SCOPING OPINION:

Proposed Castle Way Energy

Case Reference: EN0110037

28 July 2026

PROJECT	Castle Way Energy
DRAWING TITLE	Figure 1.1: Draft Order Limits
CLIENT	BSSL Derbyshire 1 Ltd

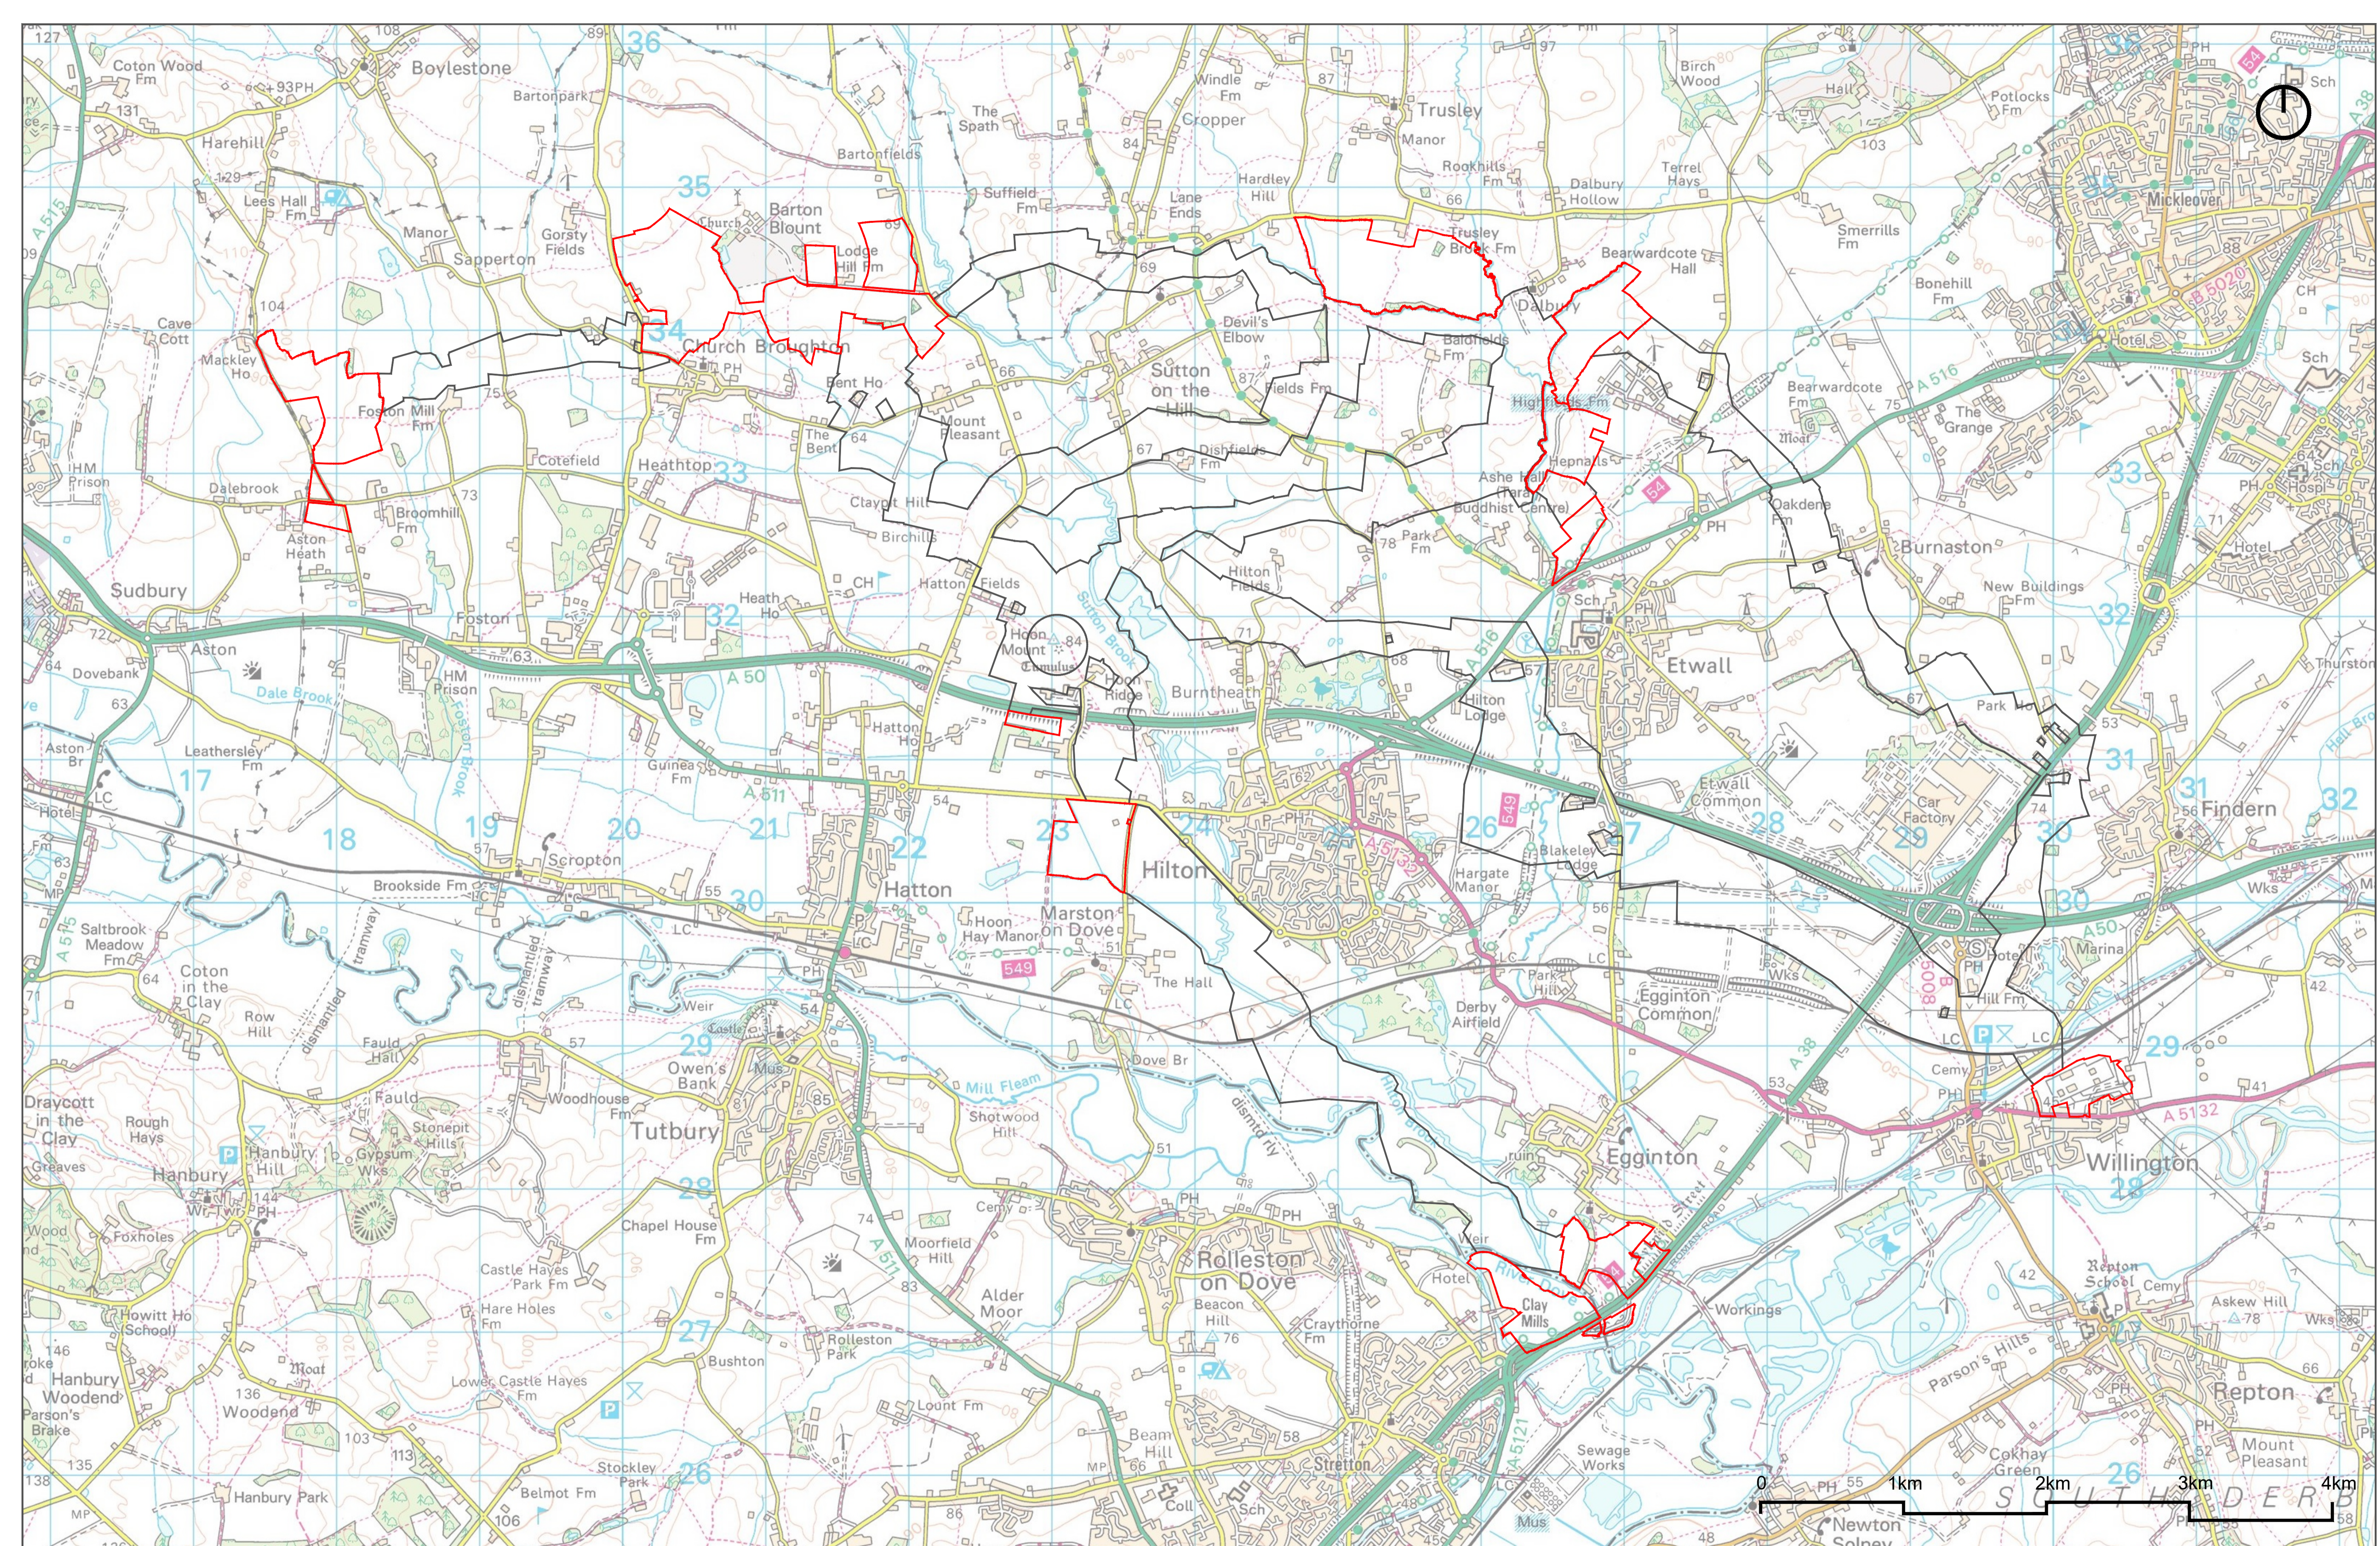
21.5	N/A	Cable route options	The Inspectorate notes the potential for up to nine cable route options/variations within the scoping report with differing environmental implications. The Inspectorate considers that

ID	Ref	Description	Inspectorate's comments
			there are receptors identified in the plans that do not appear to be identified within the scoping assessment and that therefore, depending on the Cable Corridor Option (CCO) chosen, additional impacts not considered within the ES may arise. Where this is the case, the Inspectorate would advise the applicant to undertake the scoping process again once the cable route has been selected, to ensure the scope of the assessment remains applicable to the proposed development being assessed. The applicant's attention is also drawn to the Canal and River Trust's consultation response regarding overhead crossings on their water ways (Appendix 2 of this Opinion).
